Ku-ring-gai Council Submission

Major Project MP08_0244 –Environmental Assessment –
Mixed Use Development - 23-37 Lindfield Avenue and 11 Havilah
Avenue, Lindfield

December 2010

A	DA	20	B
disc	stage	dwg no	revision

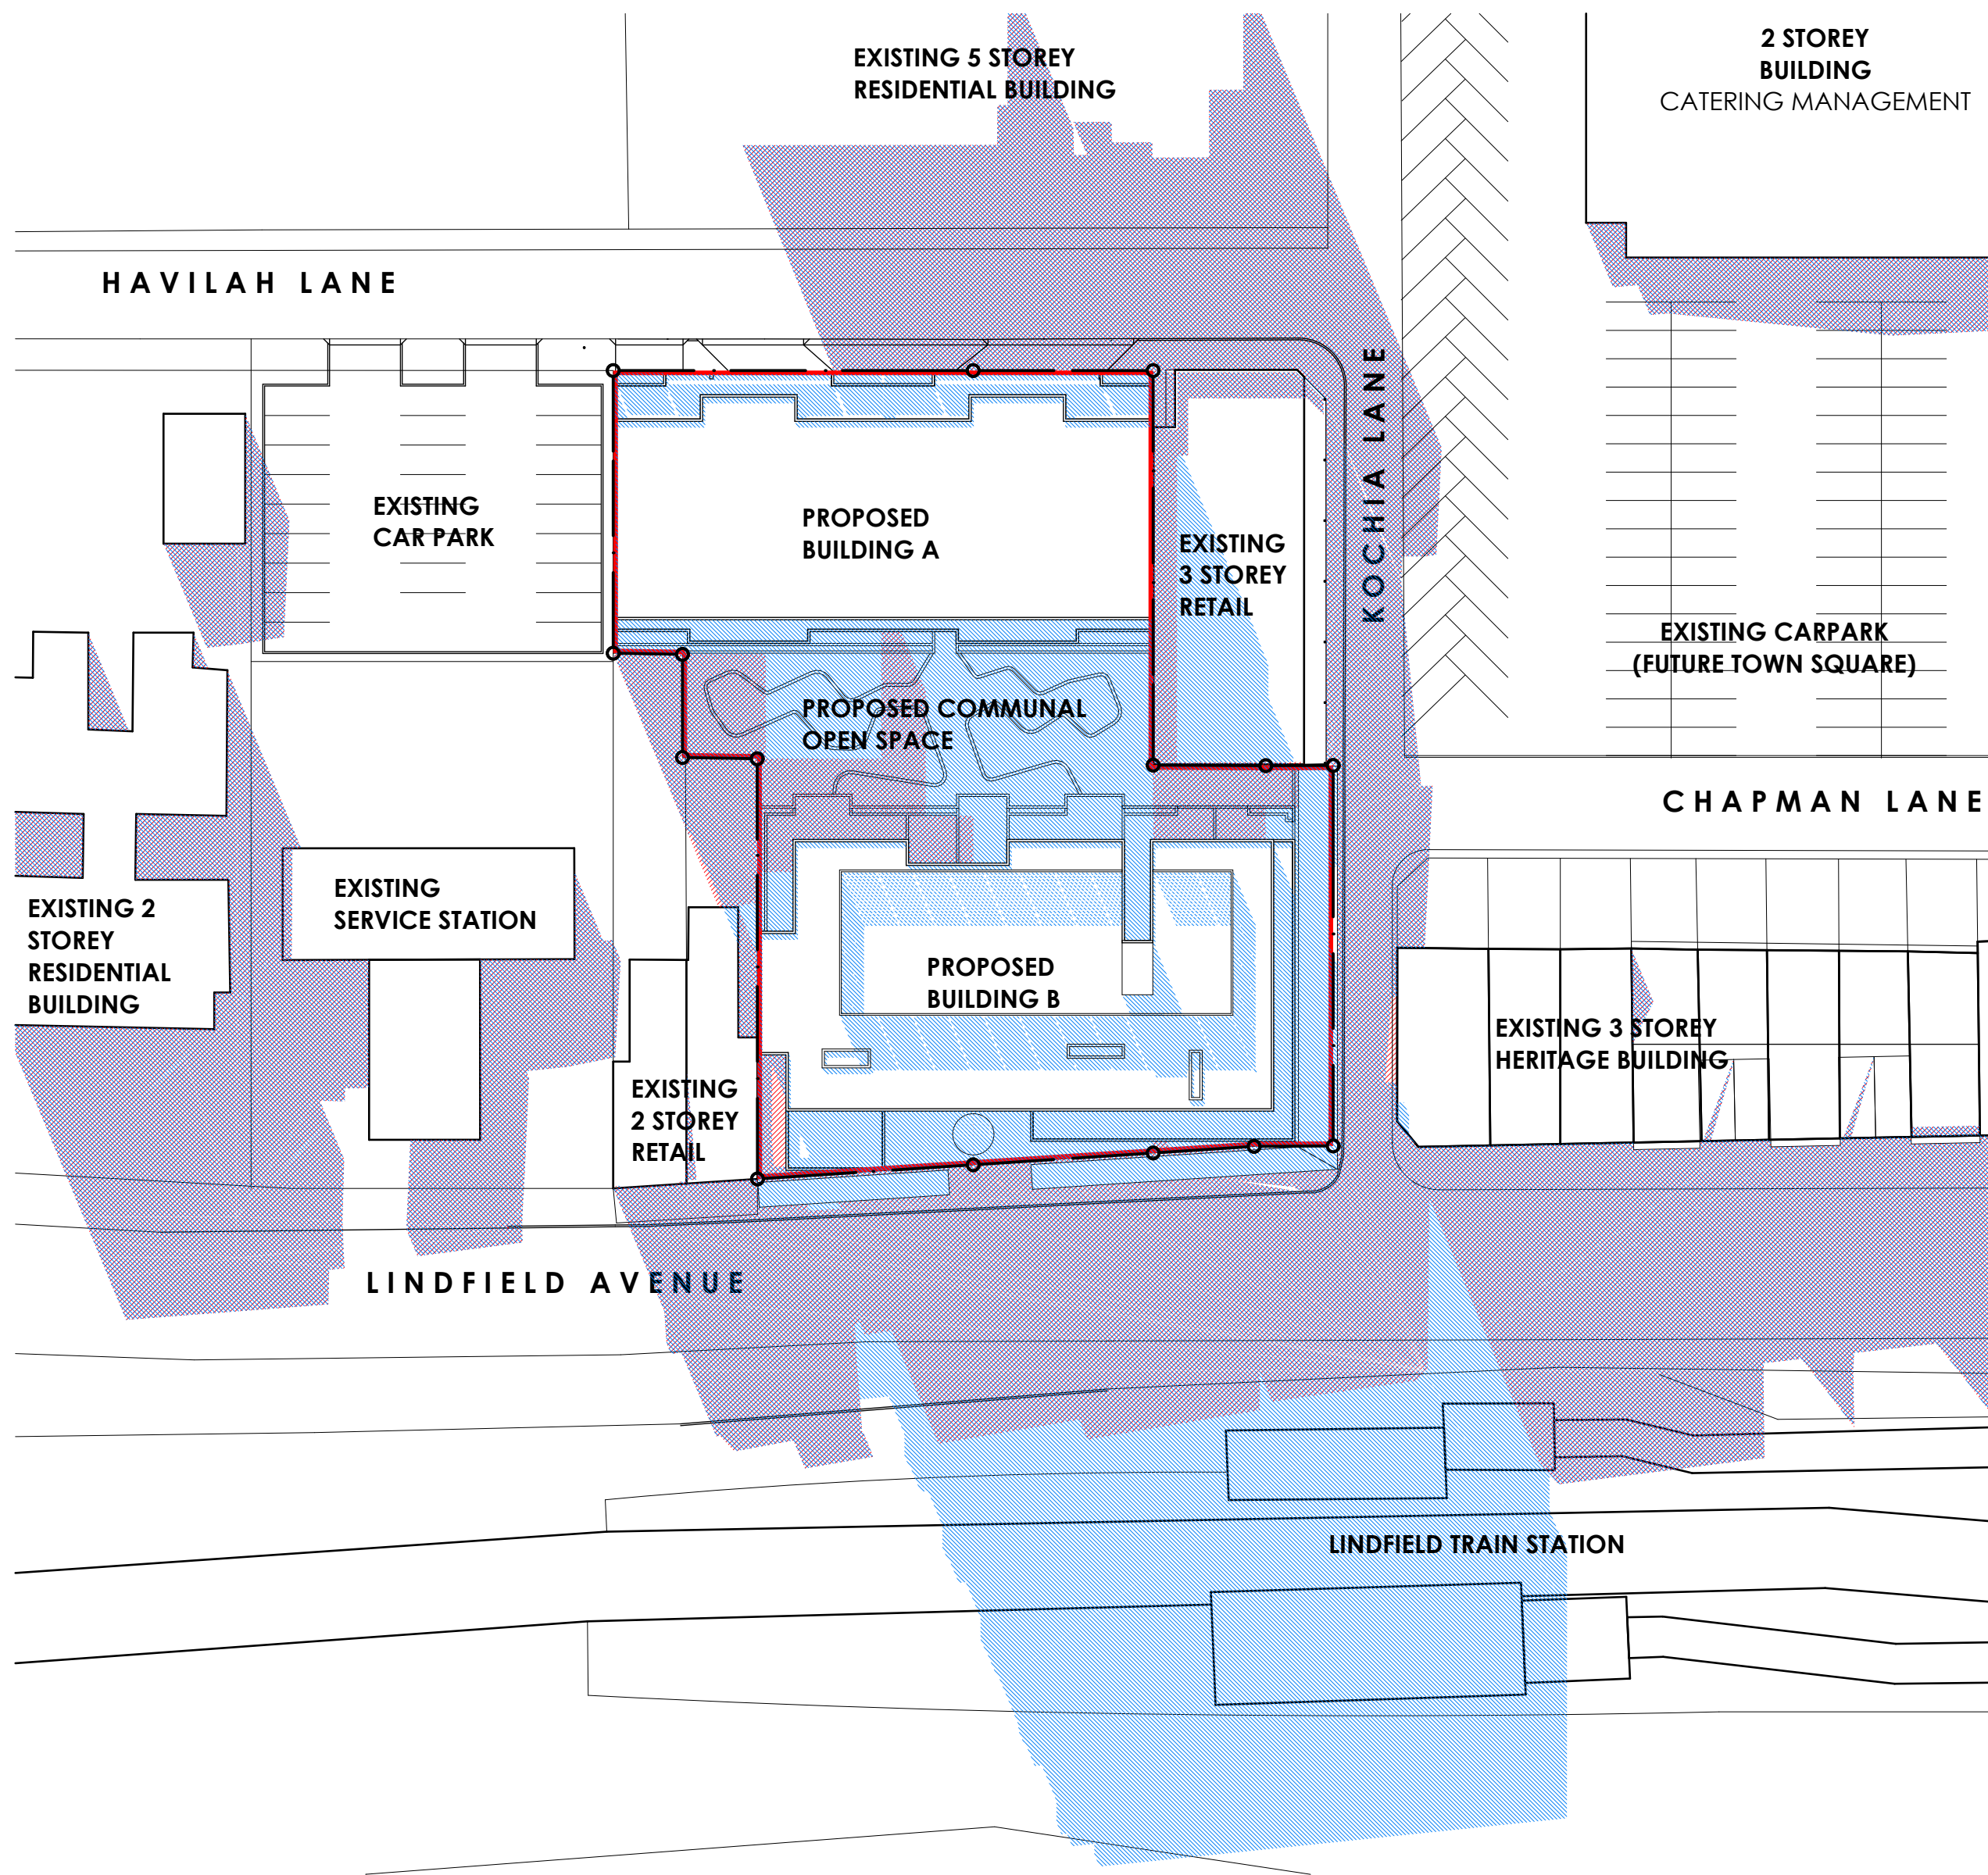
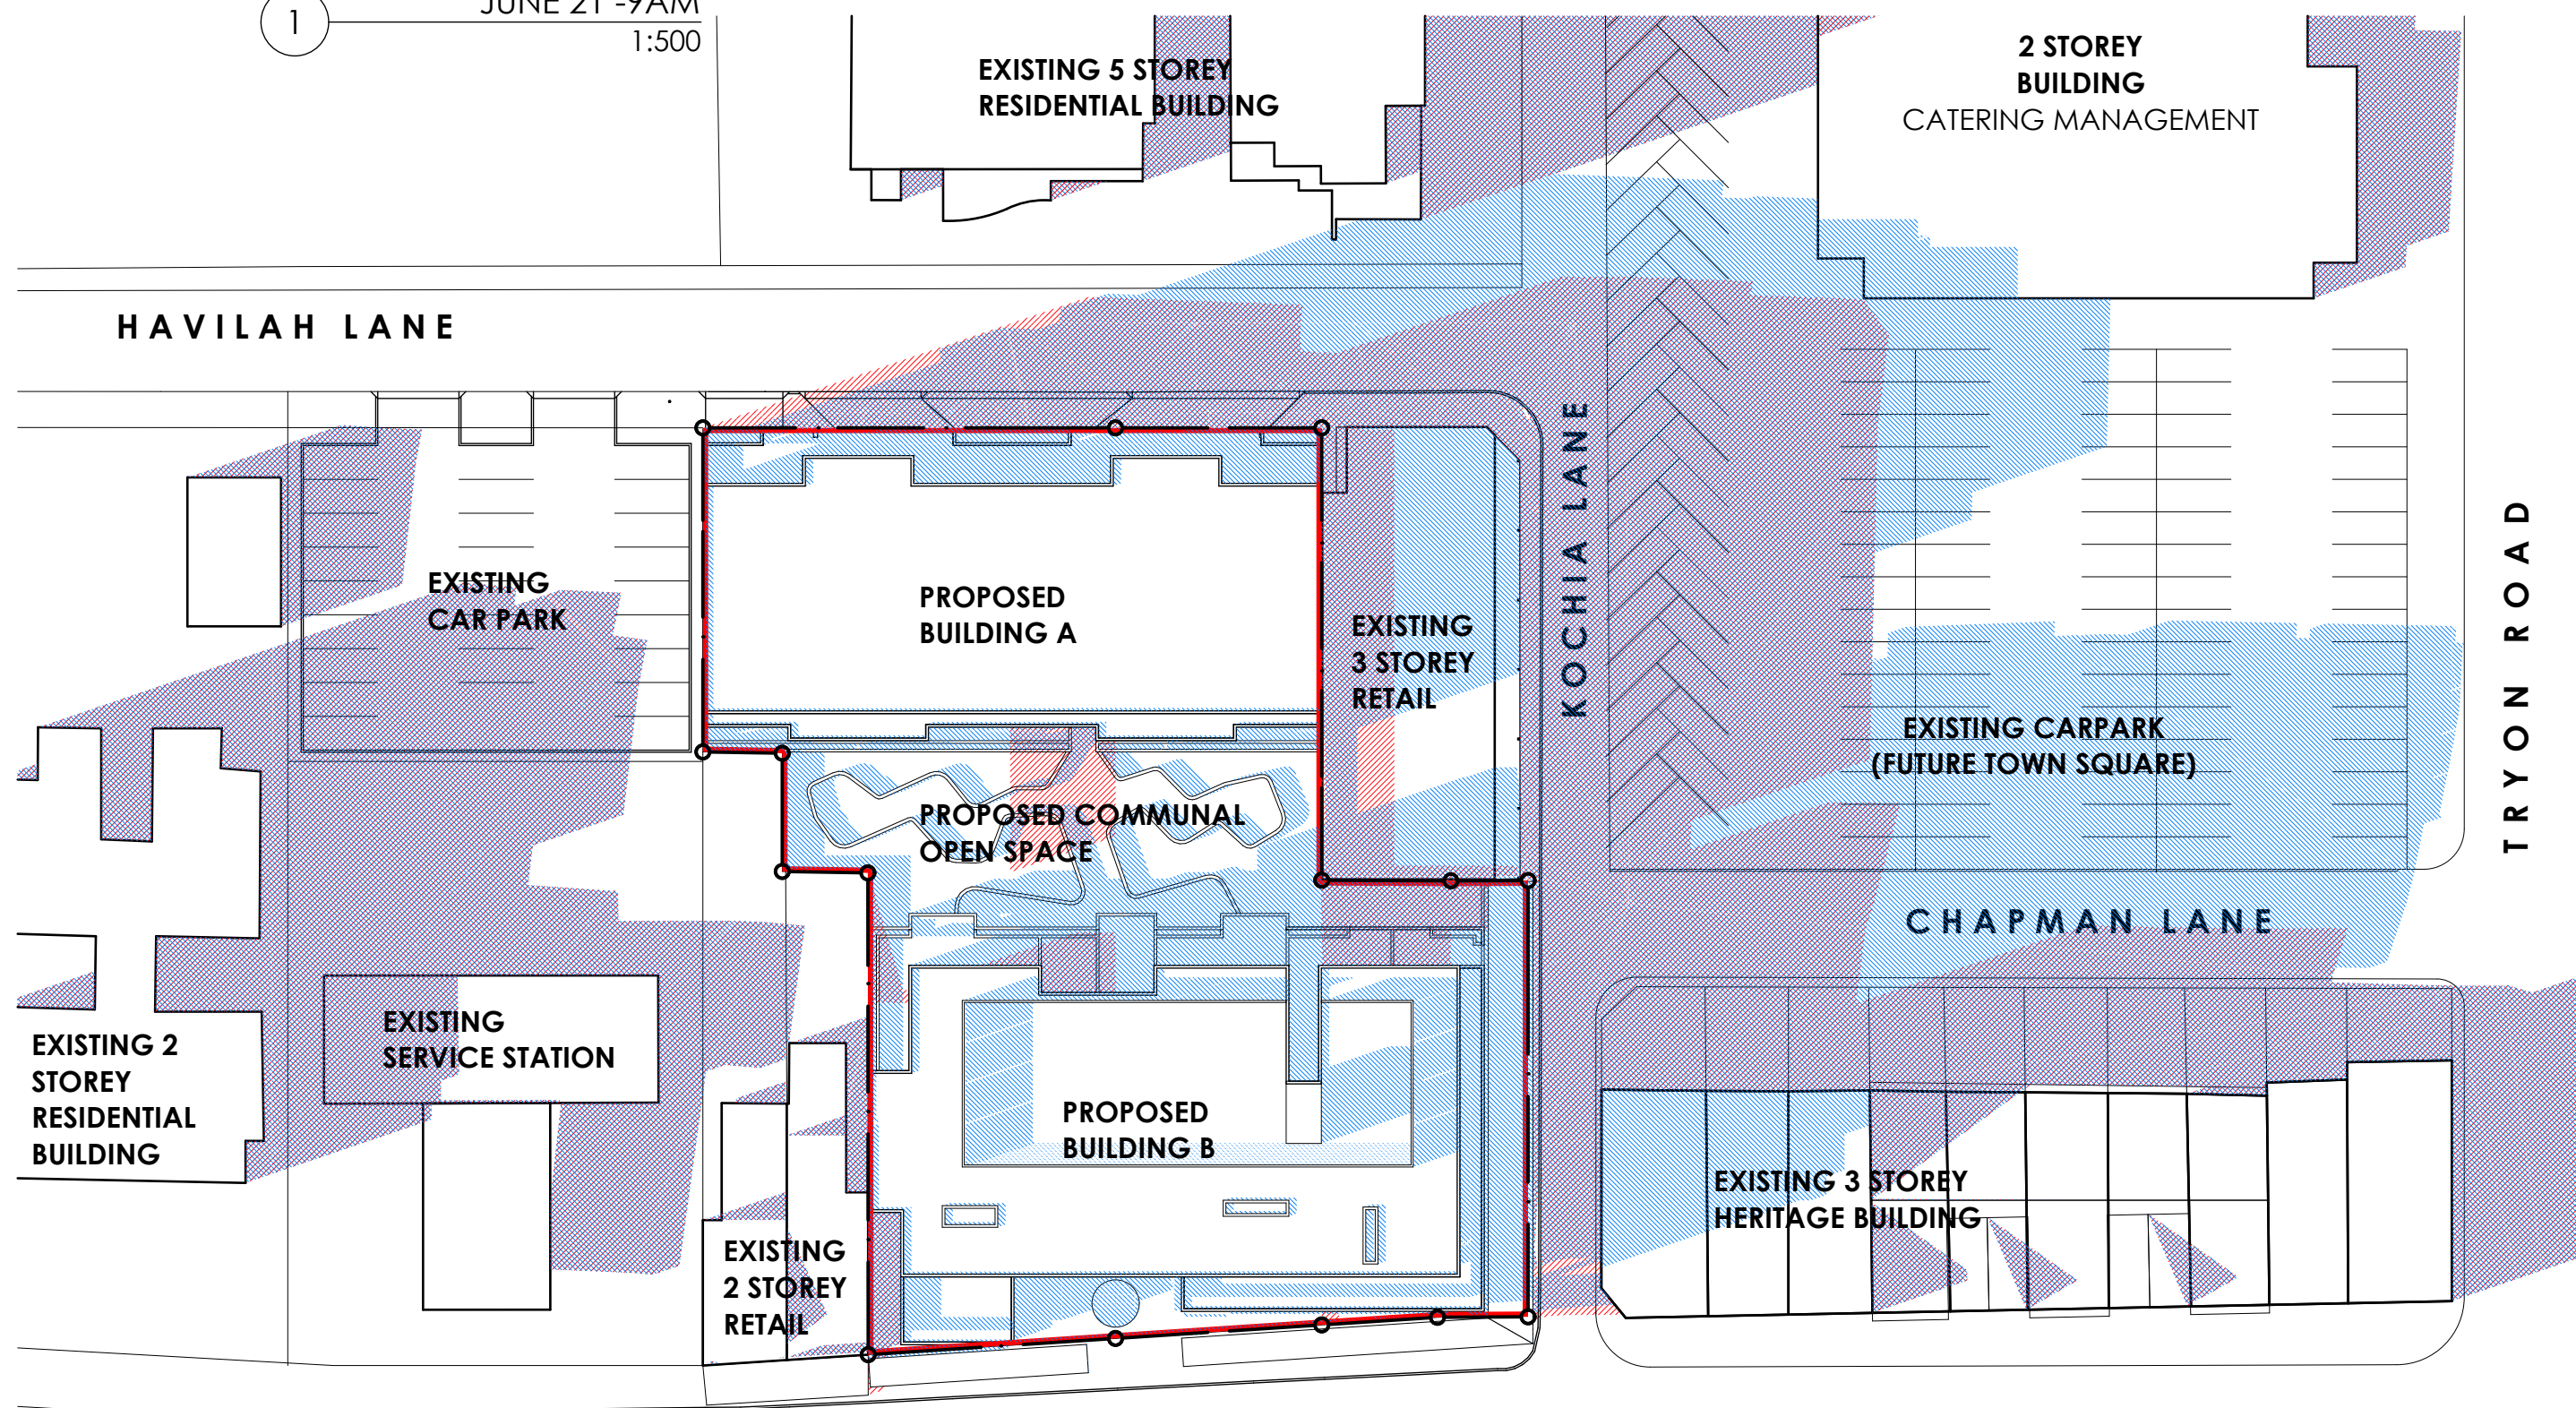
No solar access information was provided to assess compliance with SEPP 65. A report prepared by a suitably qualified person in this field is required. The report should include solar access diagrams/3d modelling addressing solar access requirements in the Residential Flat Design Code. The above report should specify the methodology of modelling, the date/time of the images, orientation of shadows cast and contain a compliance table demonstrating the performance of each individual unit referable to the solar access diagrams/3d modelling.

It is stated that the proposal does not comply with SEPP 65 in respect of solar access due to the fact that the development is located in a town centre. This is not considered adequate justification. A vastly improved outcome can be achieved through redesign as the bulk of the overshadowing is by the development itself (Block A to Block B). The inappropriate use of blade walls also significantly reduces solar access.
